CUMNOR PARISH COUNCIL

BOTLEY WEST SOLAR FARM (BWSF) REF: EN010147

Cumnor Parish Council - Comments on submissions received at D5 for D6

Map 12 Important Views of Cumnor Parish

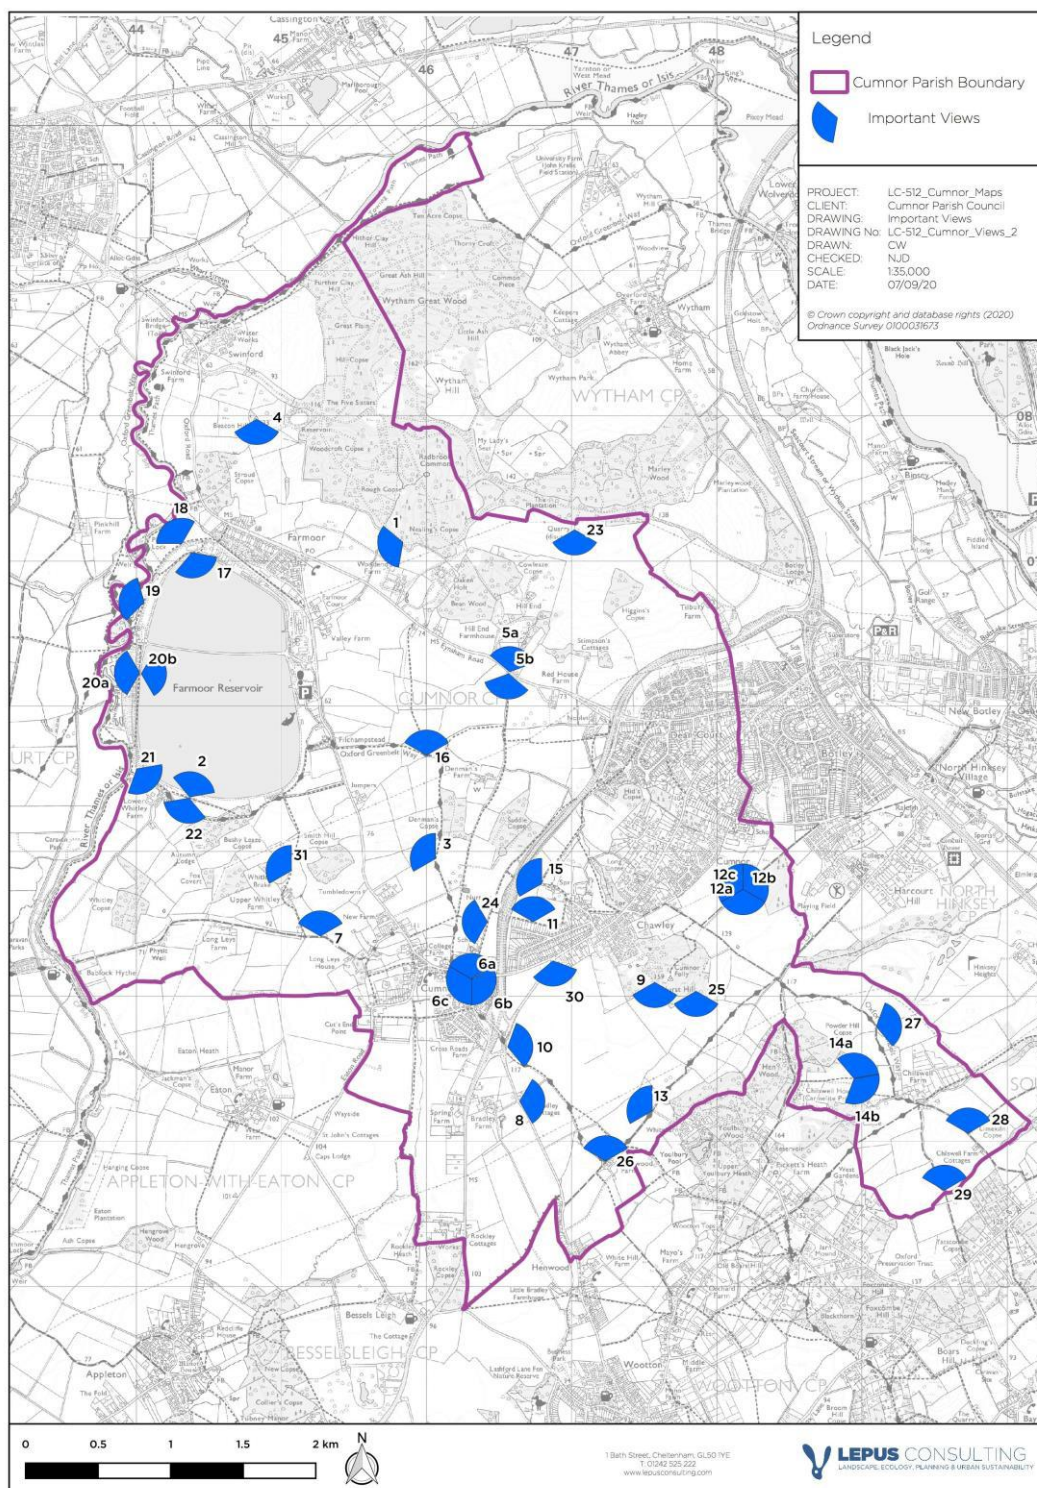
10. For Viewpoint 53, taking the photograph 1.5m from the ground from a position behind a field of fully grown maize does not accurately represent the kinetic viewpoints at and between Cumnor Neighbourhood Plan Important Views 3 and 16 (REP1-057 and REP1-062).
11. As REP1-062 (a document both approved and positively commented on by the Neighbourhood Plan Examiner) shows on page 9 and page 23, the Important Views do show the DCO site to both the west and east of the B4017 as it descends Tumbledown towards Filchampstead.
